**Northbank Enterprise Hub (MP10\_0185)  
Exhibition of Environmental Assessment**

The National Trust owns and manages the State Heritage Register listed Tomago House which is surrounded on three sides by this development proposal. The Trust was not included as one of the stakeholders in the formal Stakeholder Consultation.

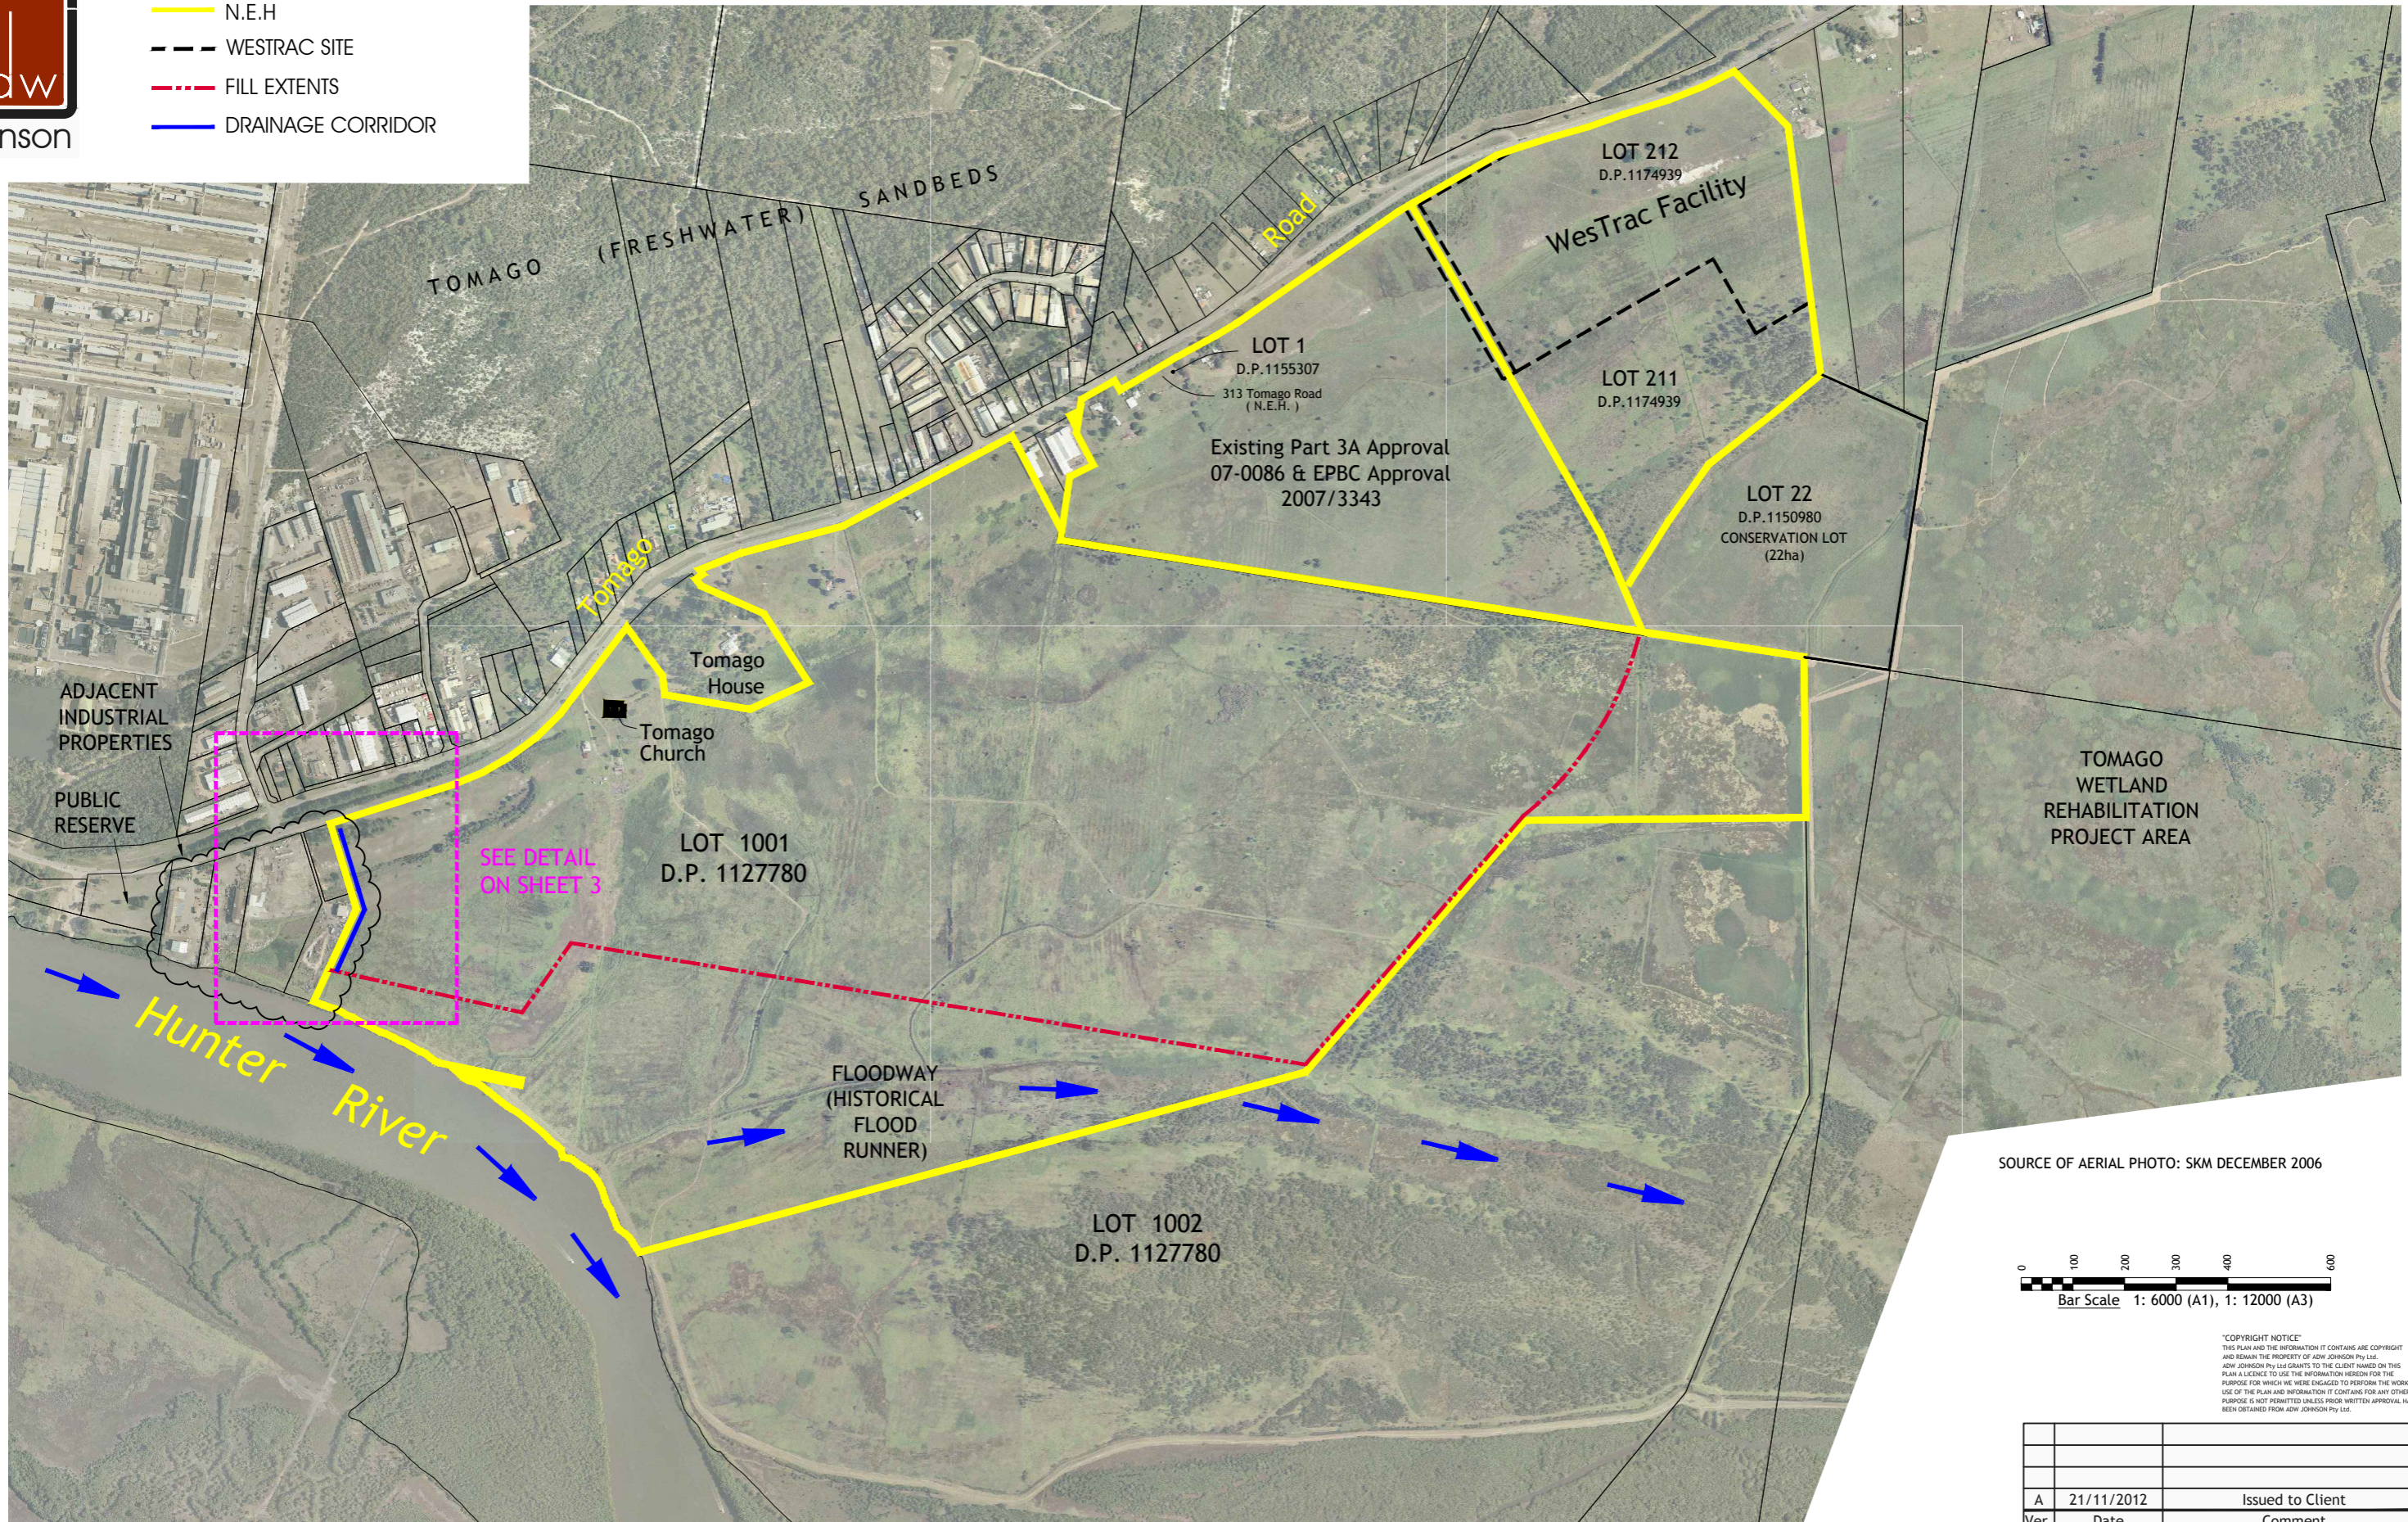
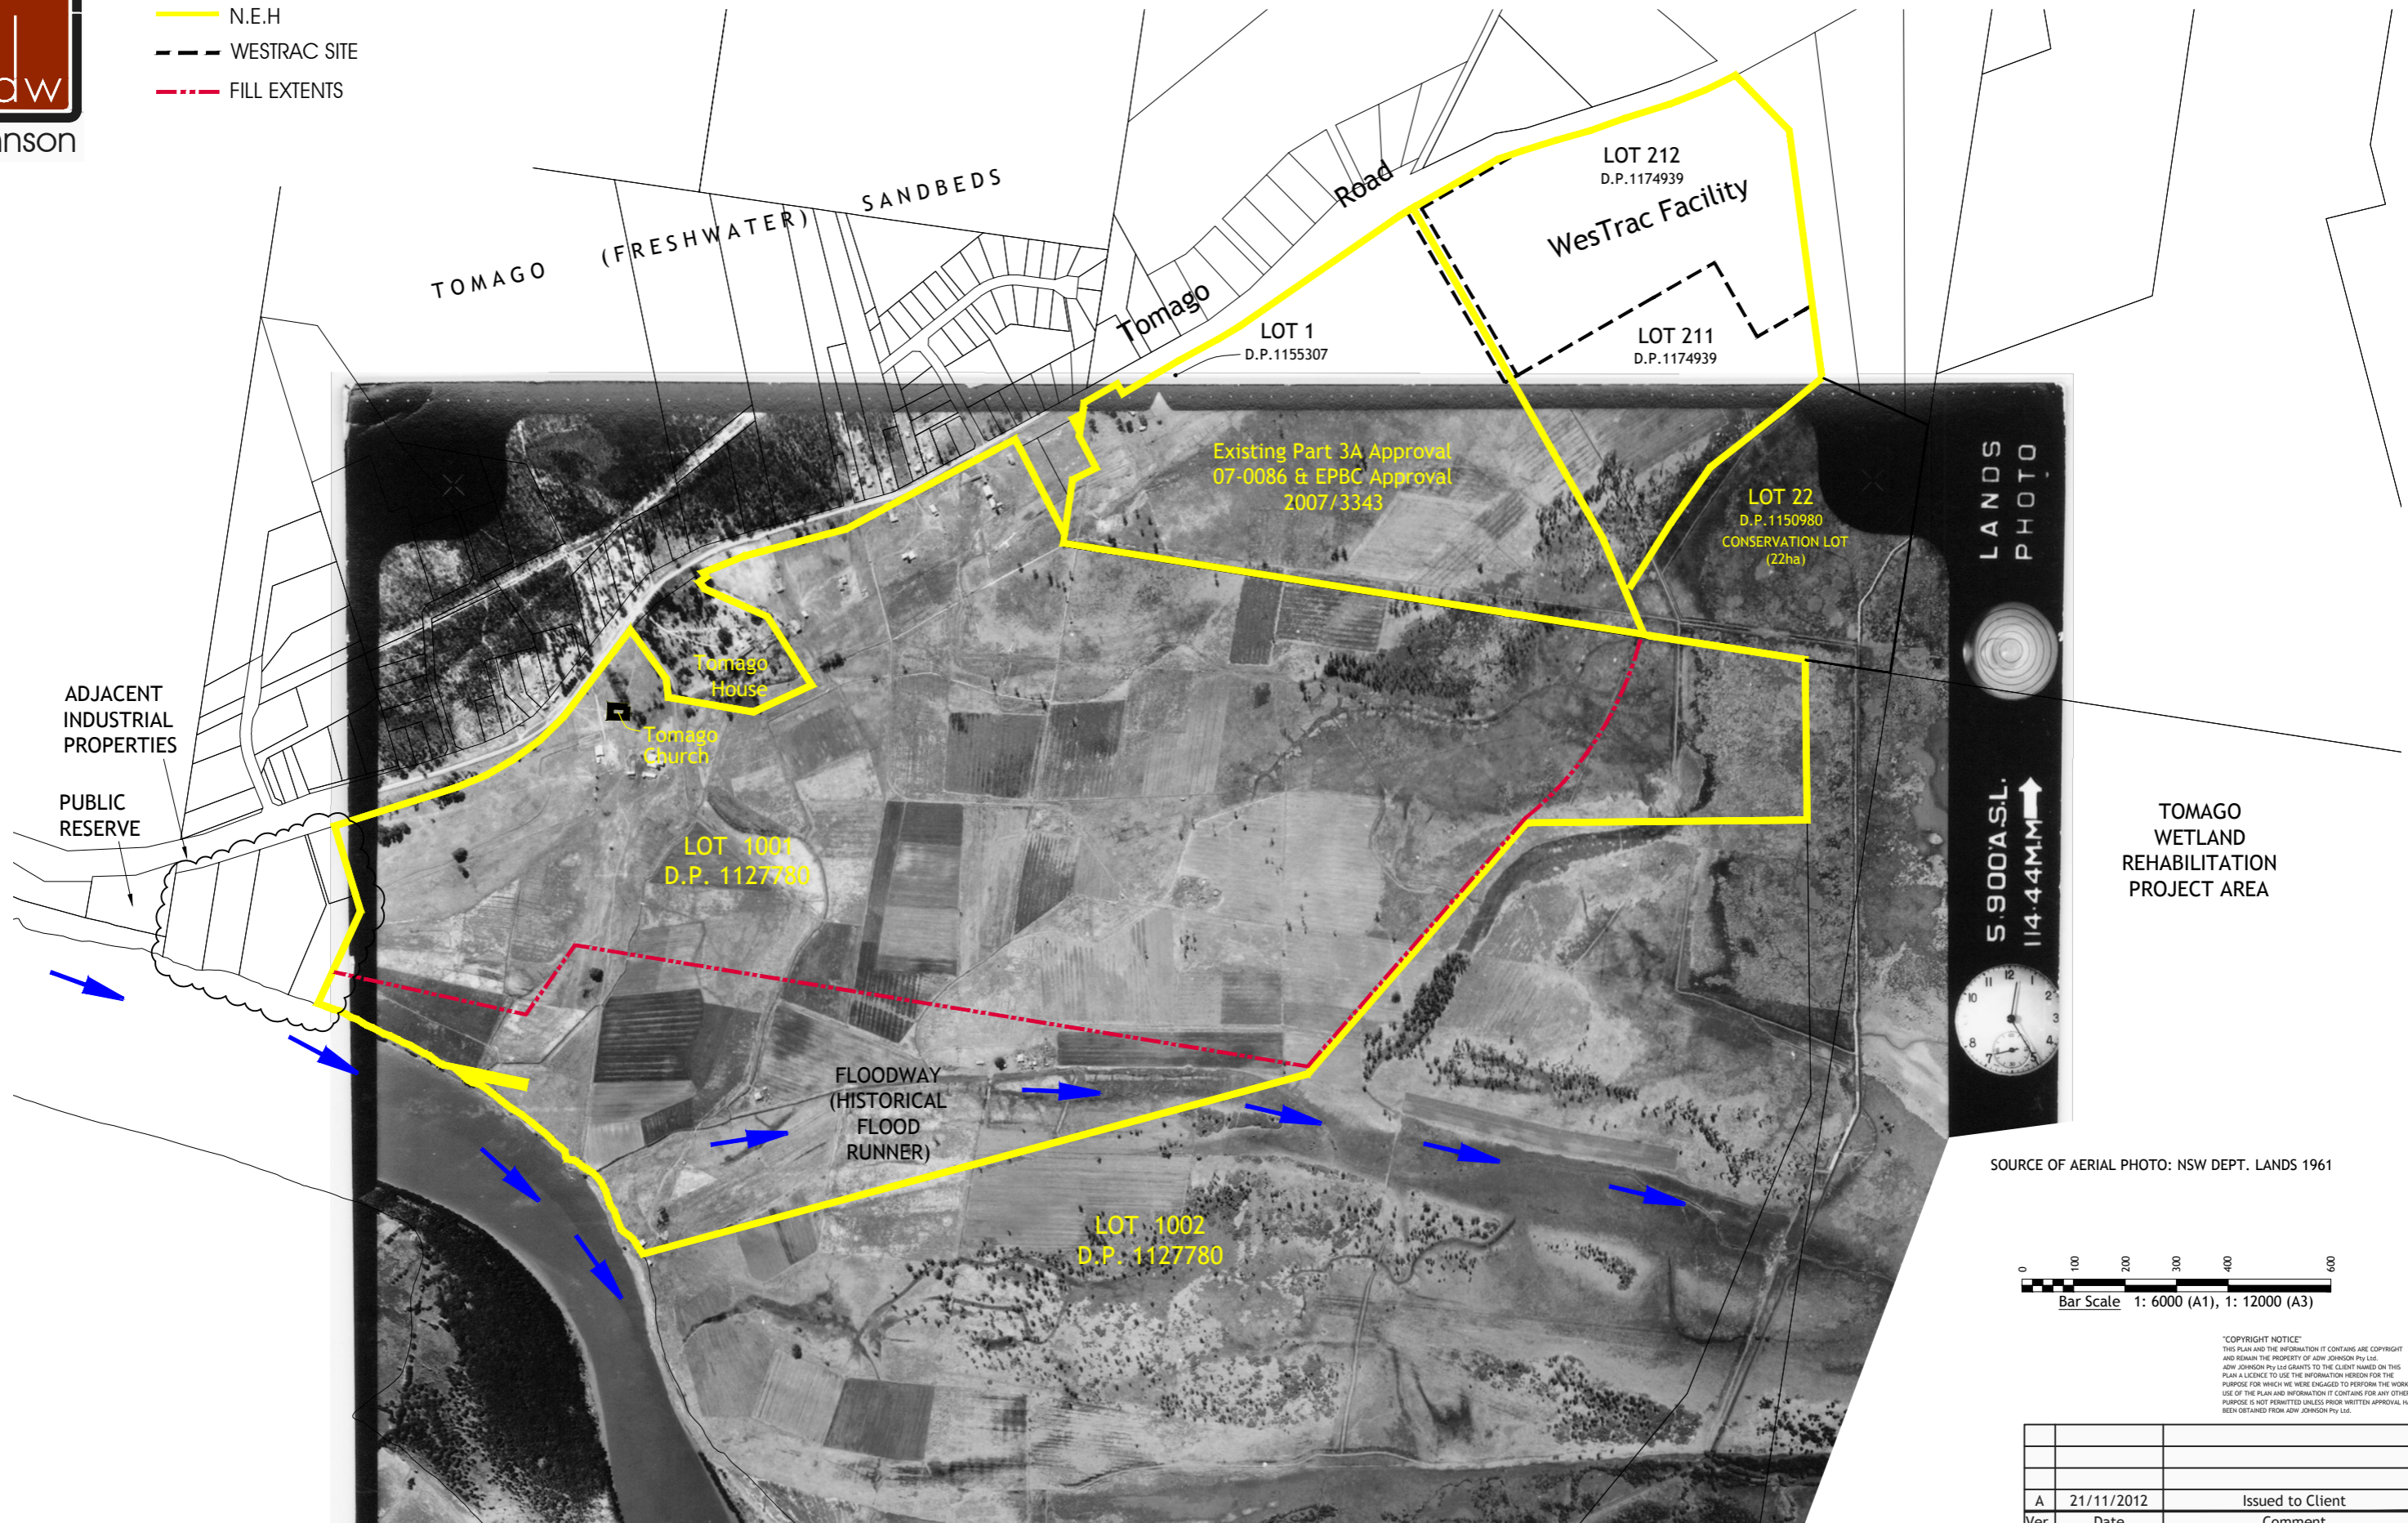
1. Filling of the lands to the south and south-east of the Trust’s Tomago House and Chapel and the eventual construction of industrial buildings on these lands will degrade the “historical setting to Tomago House and Chapel” and will impact adversely on the operation and viability of Tomago House and its chapel to operate as a *historic property, function and events centre and a place to visit on the tourist trail*.

2. Filling of these lands will leave a significant depression on the National Trust State Heritage Register listed property directly behind Tomago House and this may result in worsening the drainage problems on the National Trust property and the incidence of major mosquito infestation.
